RE: EPC SF2219 – Mayberry Filing 3 Drainage Report Comment Response

FINAL DRAINAGE REPORT

MAYBERRY, COLORADO SPRINGS – FILING NO. 3

SF2219

**DRAINAGE CHANNEL C2  
PLAN & PROFILE**

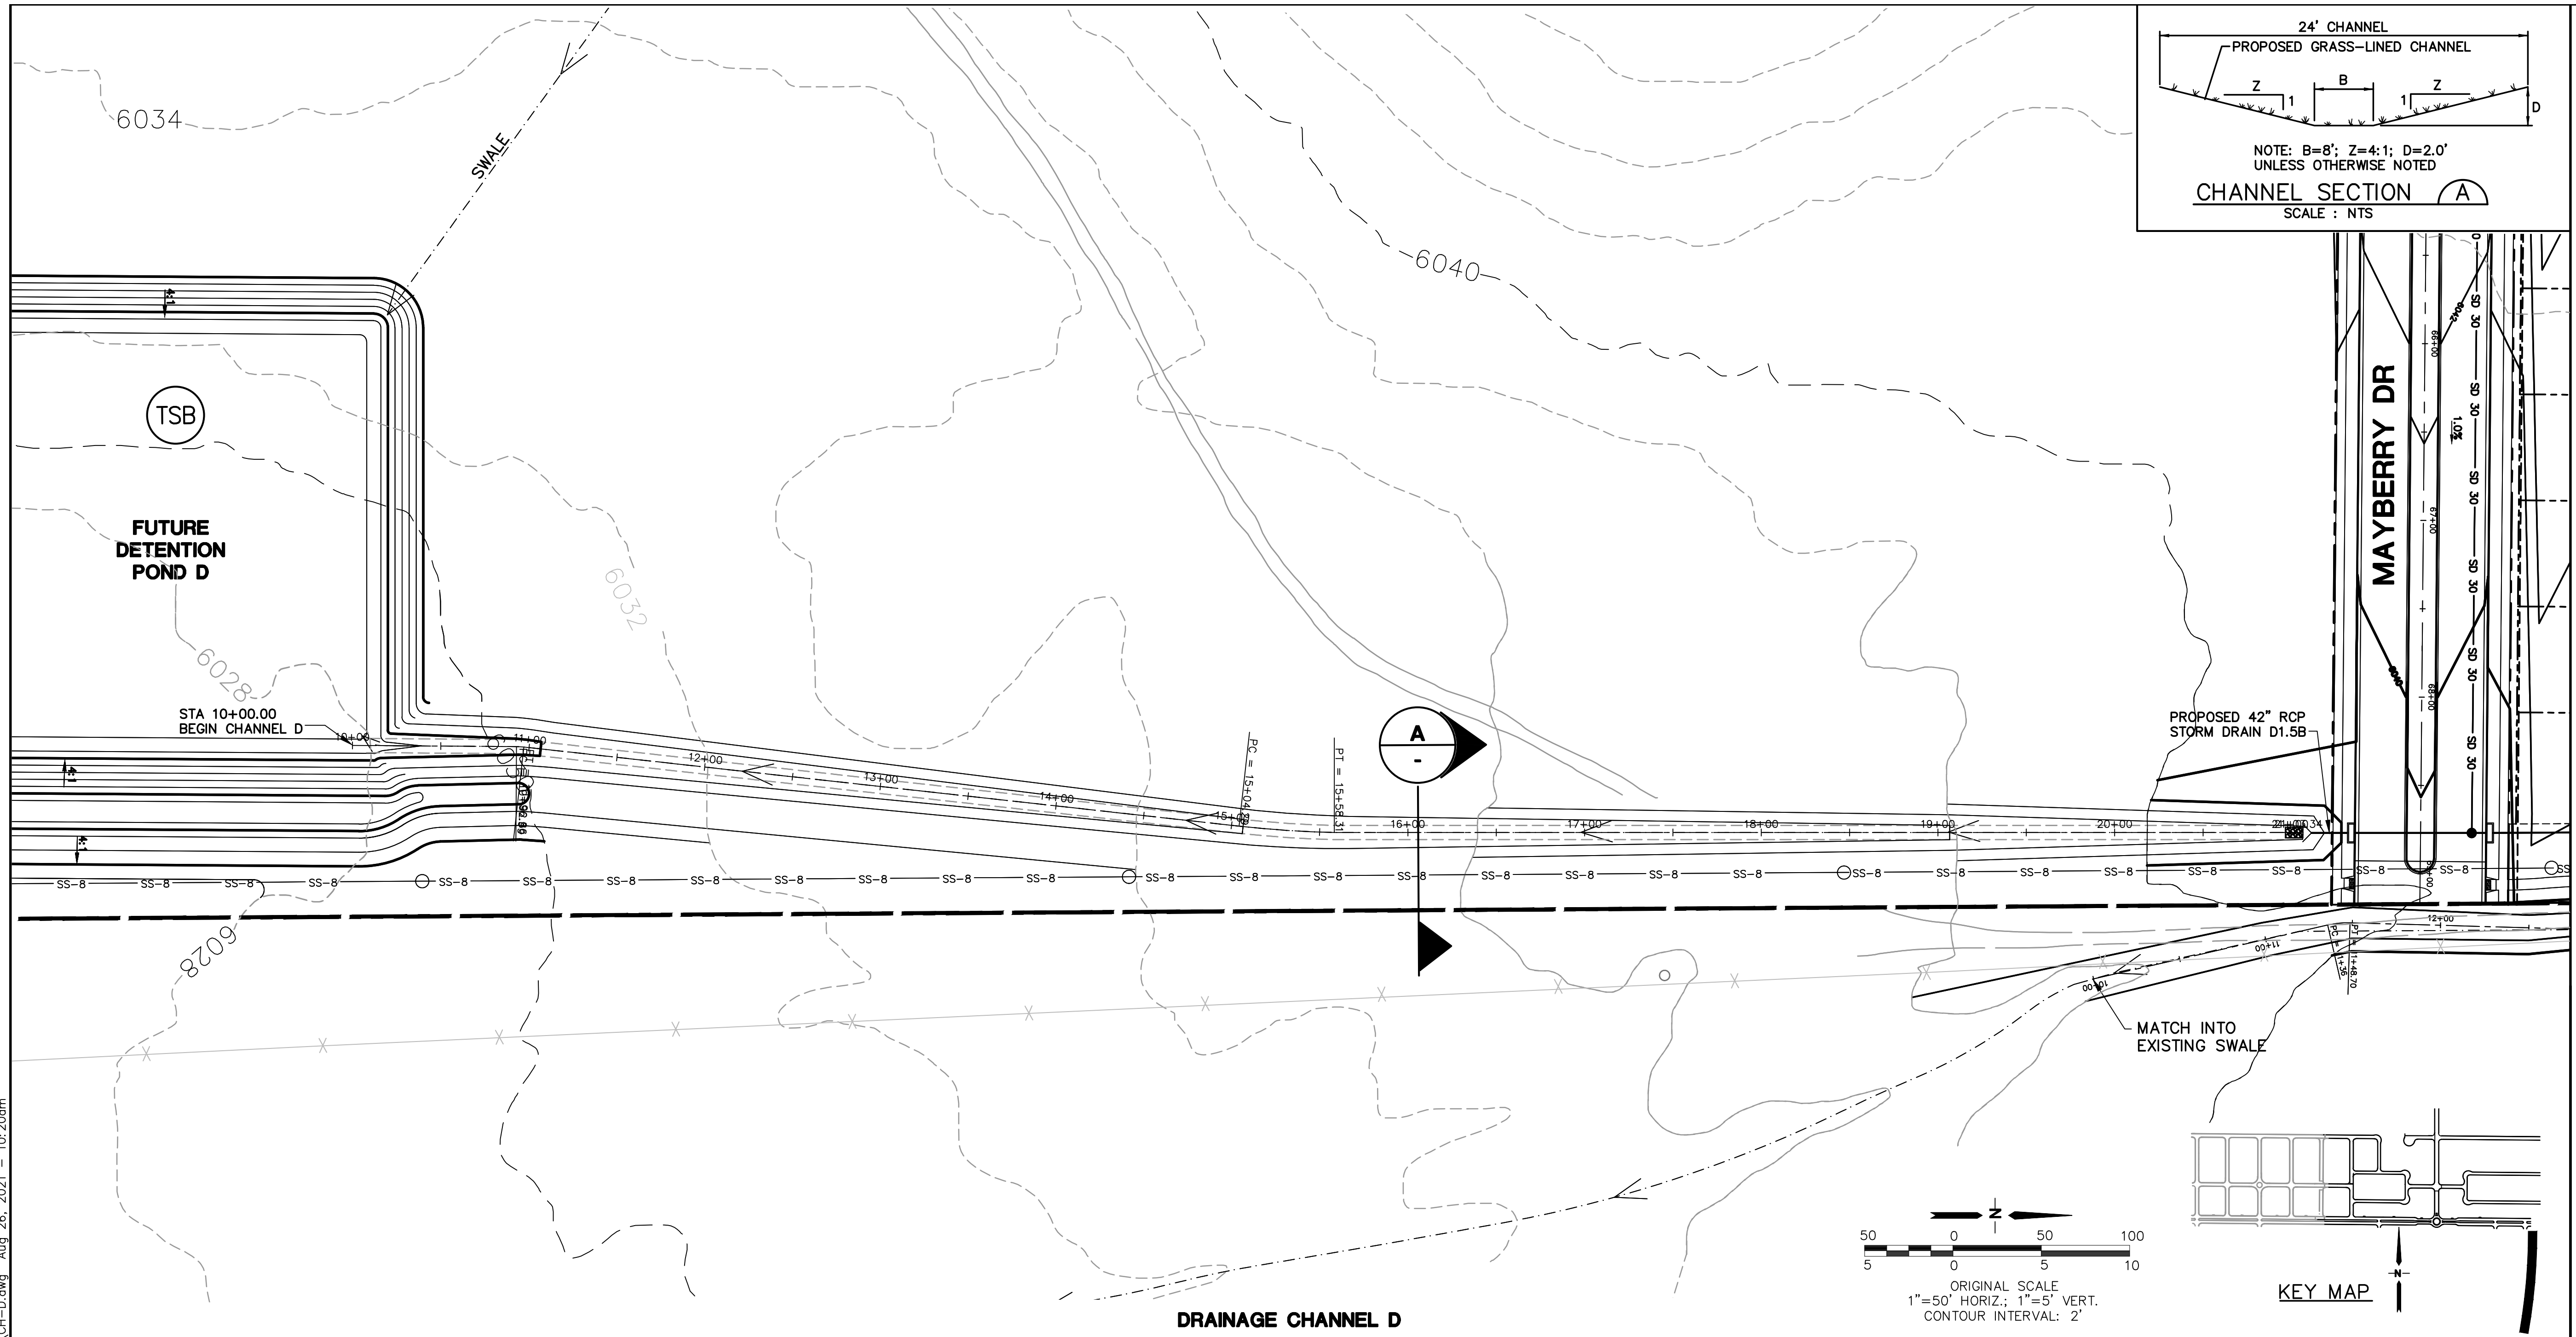
- More defined channels are shown as part of this resubmittal where channels were shown to abruptly terminate previously. More specifically, channels C2 and E were extended to provide adequate outfalls. A new channel (Channel F) provides a stable conveyance for flows leaving Pond D. Previously, this was shown as a flow arrow with a note to daylight.

POND D PROFILE VIEW  
HORIZONTAL SCALE: 1"=40'  
VERTICAL SCALE: 1"=8'

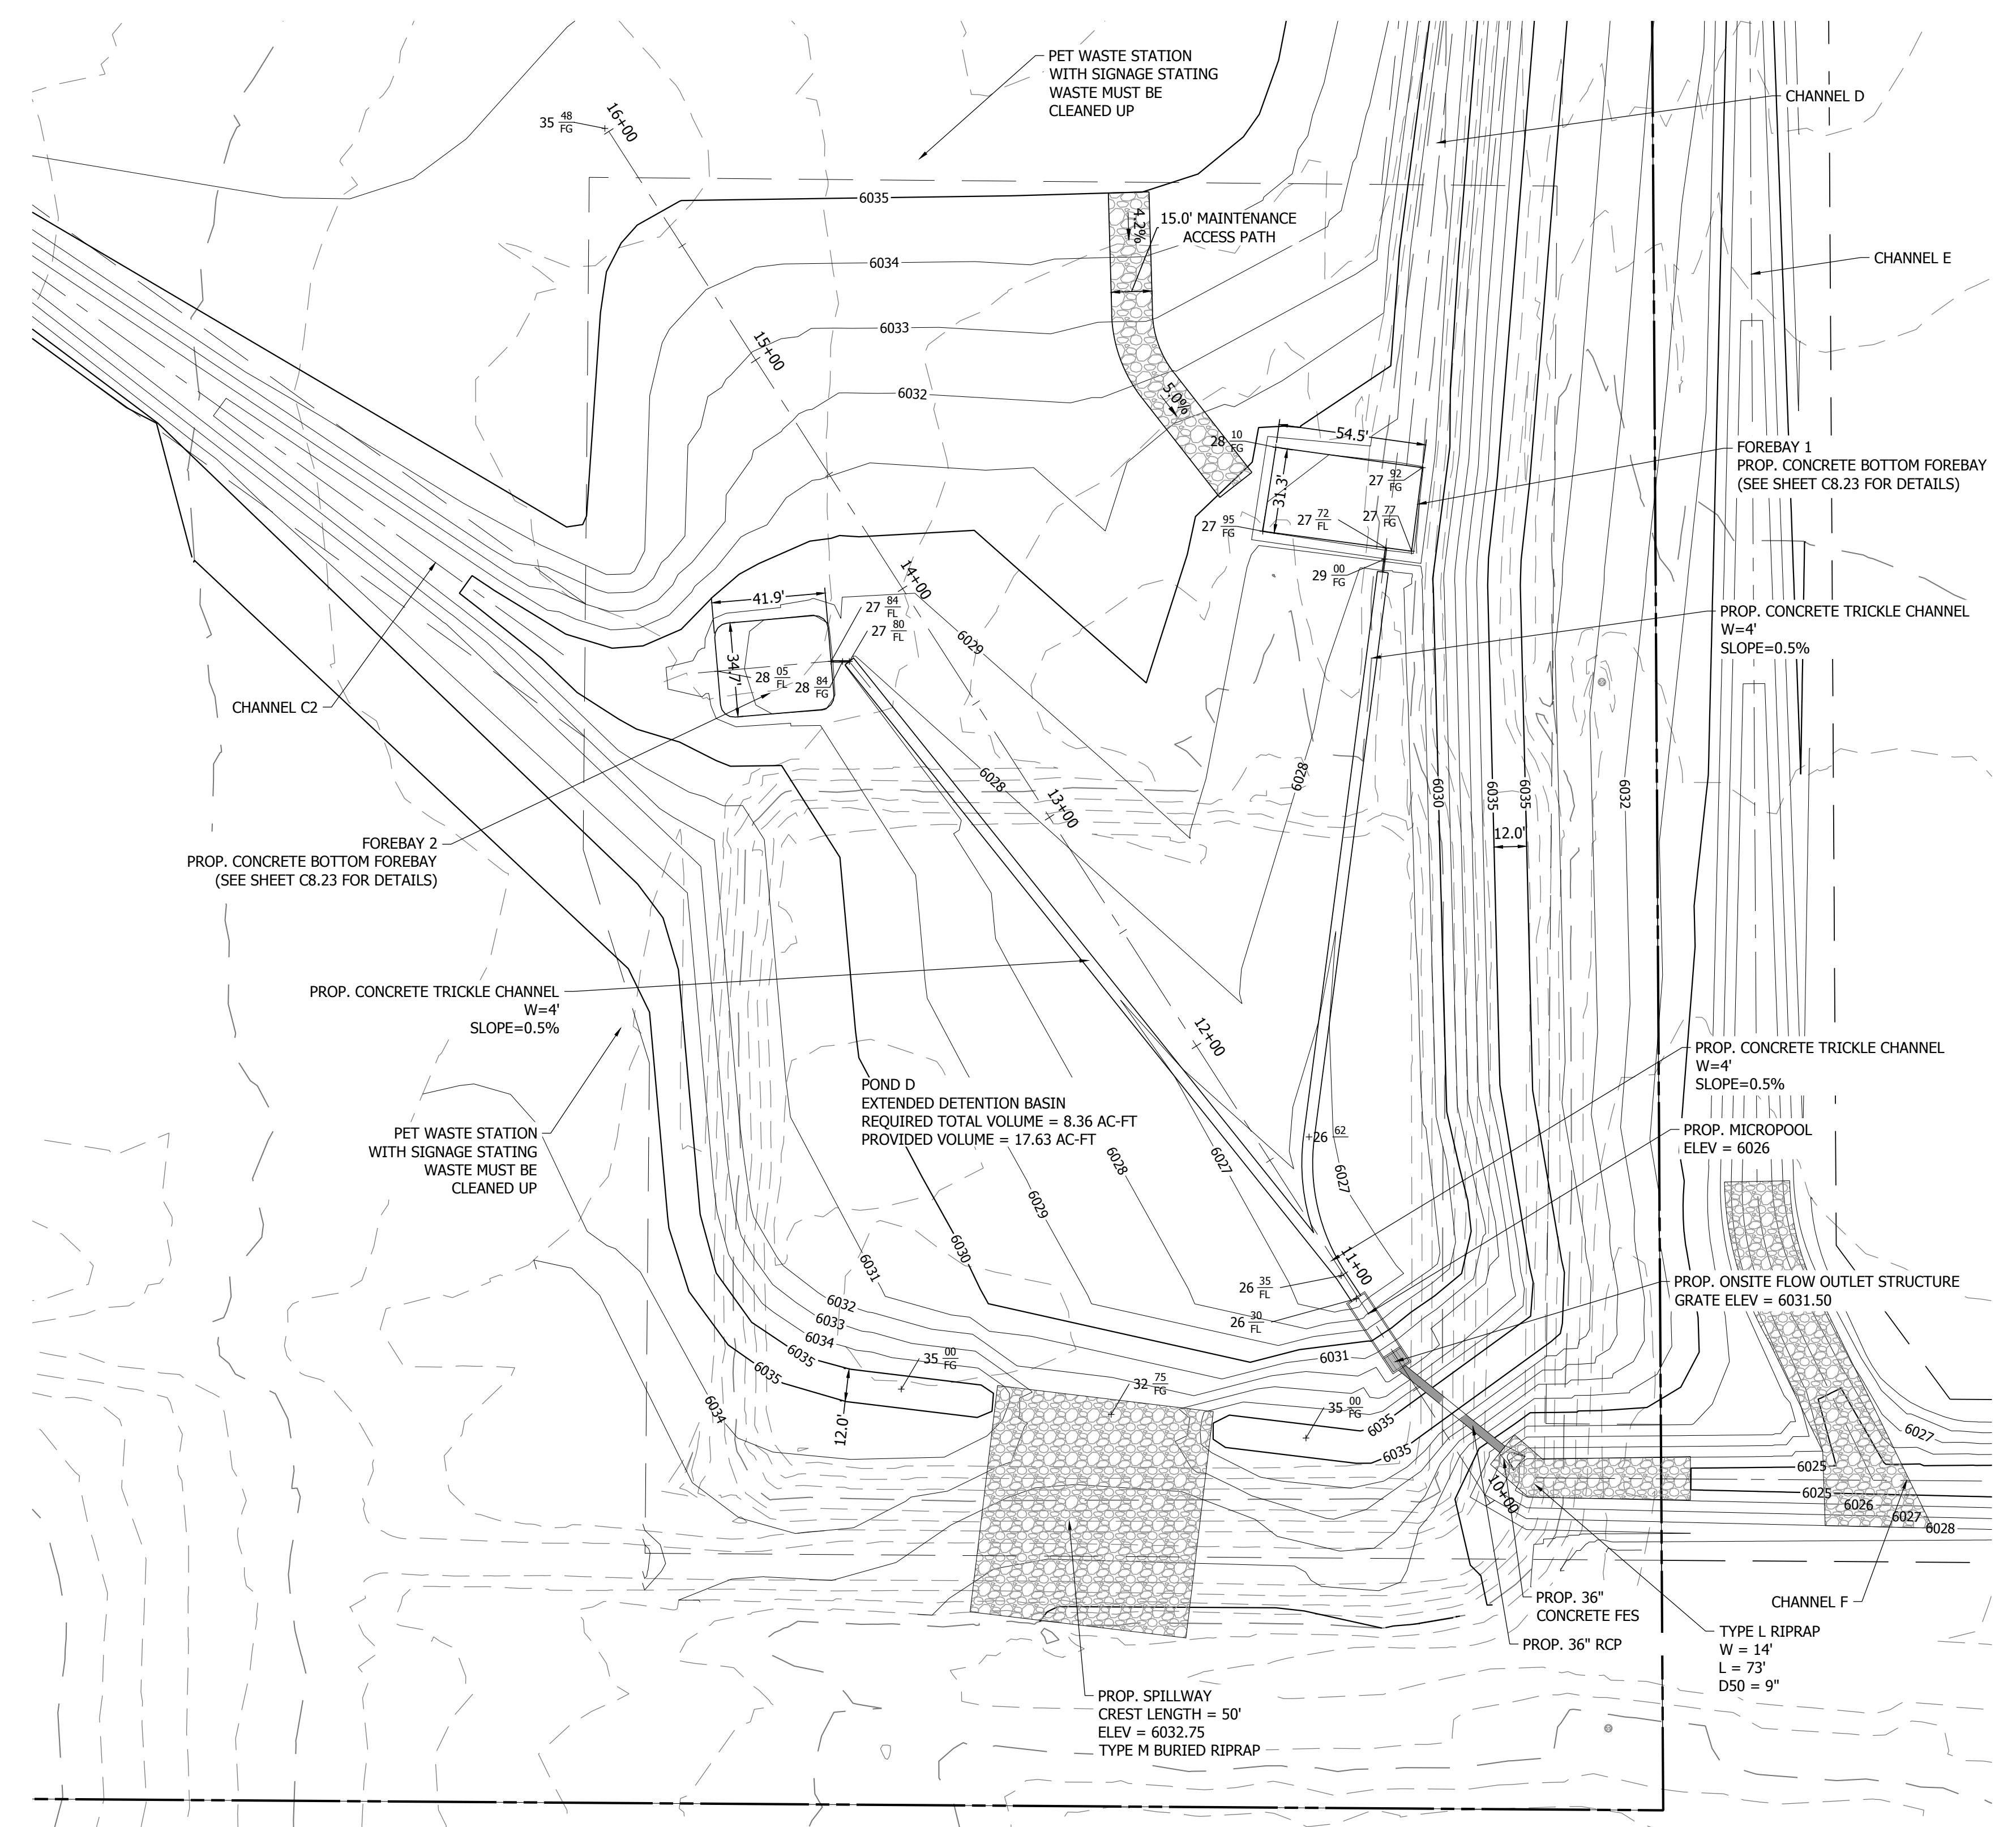
- Detention Pond D was redesigned to provide 3% slopes to trickle channels within the pond
- An additional forebay and trickle channel was added where Channel C2 discharges into the pond
